PLANNING CONSULTATION RESPONSE

Application No	2026/0613
Proposal	Amalgamation of 2x existing flats and change of use to create 12 bedroom HMO (Use Class Sui Generis) with associated works.
Address	42 Doncaster Road, Barnsley, S70 1TL
Date of Consultation Reply	13.08.26
Consultee	Stacey Fieldsend – Case Management Officer

. - 417.01.2 - Proposed First Floor and Second Floor Plans

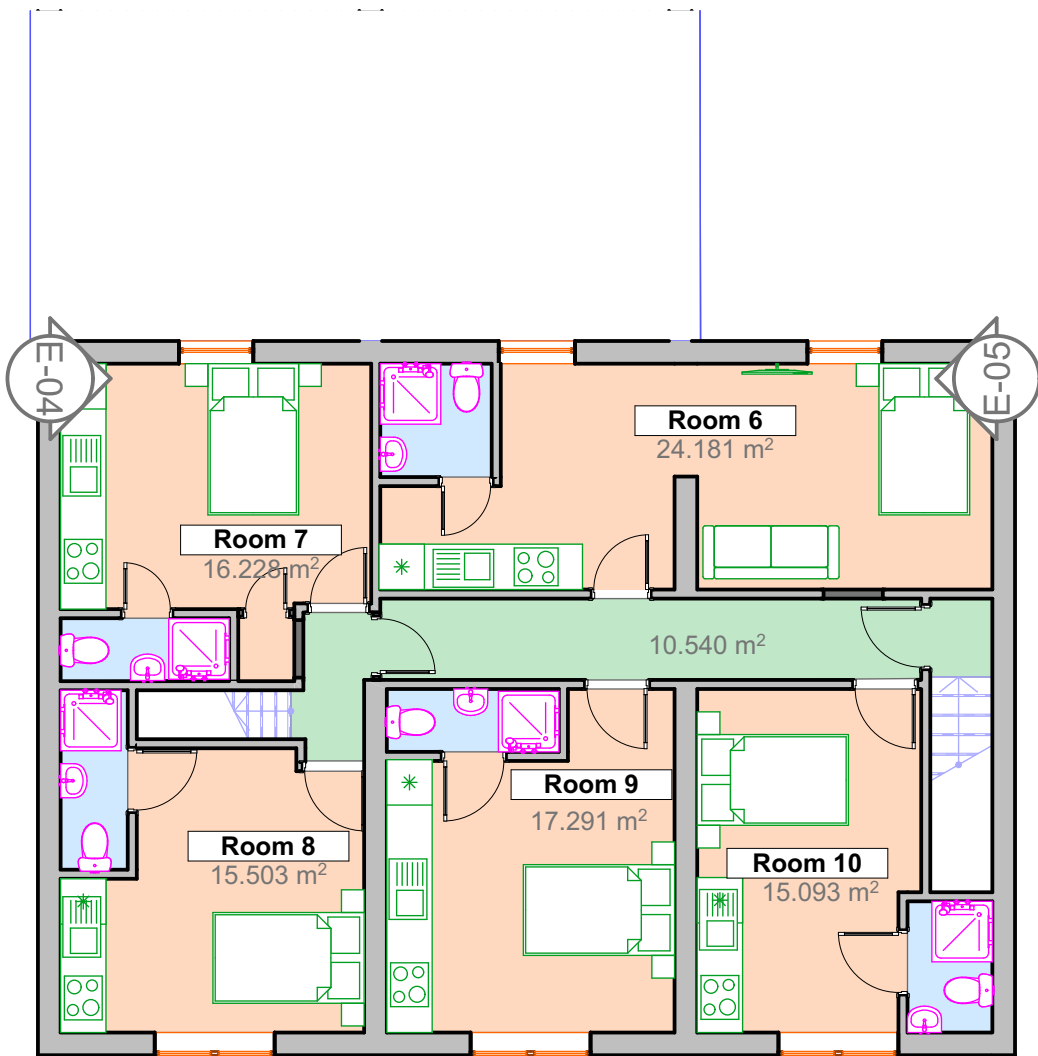
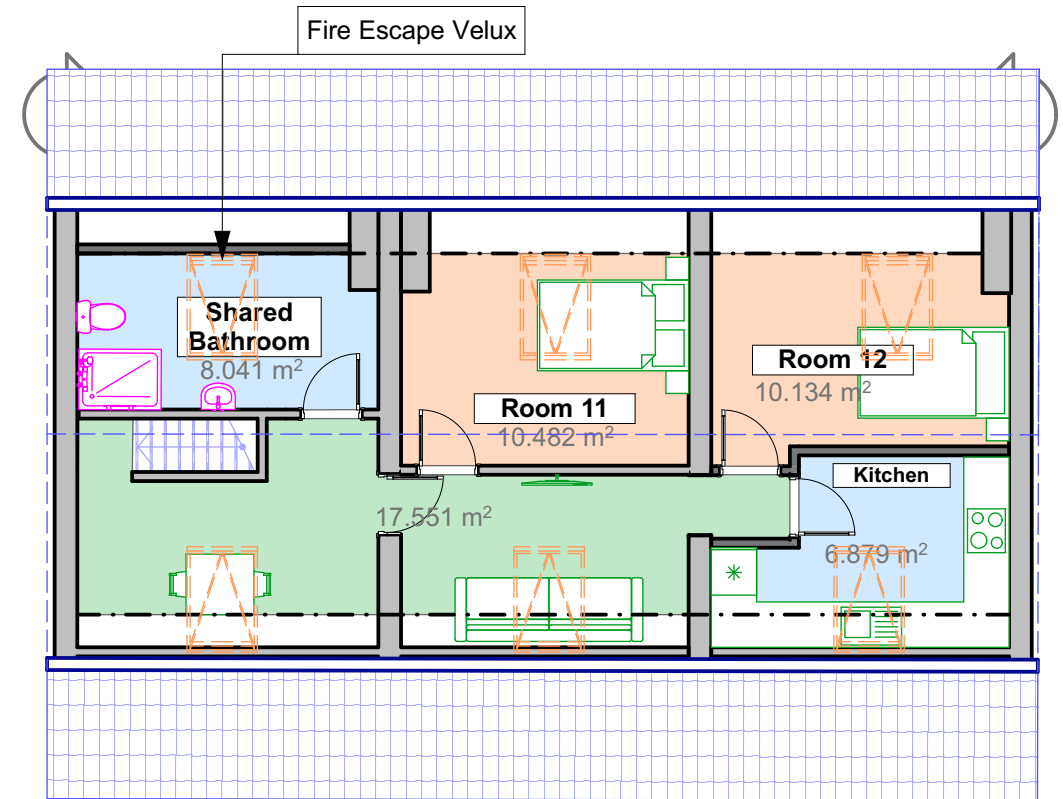
The proposed 12-bedroom HMO includes second-floor/loft accommodation served by rooflights identified as escape windows. However, insufficient information has been provided to demonstrate that the proposed means of escape are adequate for a multi-storey HMO. In particular, details of the fire strategy, protected escape route, emergency lighting, fire alarm system and the specification of the proposed escape rooflights have not been submitted. As the HMO is also located above/adjacent to retained commercial premises, further information is required to demonstrate that suitable compartmentation, including 60-minute fire separation between the commercial and residential elements, can be achieved. A fire strategy and supporting fire risk assessment should therefore be provided, and South Yorkshire Fire and Rescue should be consulted, to confirm that appropriate fire safety measures, means of escape and fire separation are in place.

The submitted floor plans also appear to show communal soft furnishings within landing and hallway spaces. This is not considered acceptable, as these areas form part of the protected fire escape route and should remain clear of furniture, combustible materials and other obstructions. Every new HMO should be provided with suitable communal living accommodation, either as a separate living room or a combined living/dining room. For a 12-bedroom HMO of this scale, the communal living/dining room would be expected to have a minimum floor area of 17.5m². Two shared kitchens would also be expected for a building of this size, with a combined minimum floor area of 15m². The proposed plans appear to meet the kitchen provision requirements; however, amended plans should be provided to remove any proposed soft furnishings from the escape route and demonstrate that an appropriately sized communal living/dining room can be provided within the HMO accommodation.

5. Prior to first occupation of the HMO, amended plans shall be submitted to and approved in writing by the Local Planning Authority demonstrating that no soft furnishings, furniture or combustible items are located within the protected escape route, including hallway and landing areas. The amended plans shall also identify a suitable communal living room or combined living/dining room with a minimum floor area of 17.5m². The approved layout shall be implemented prior to occupation and retained thereafter.
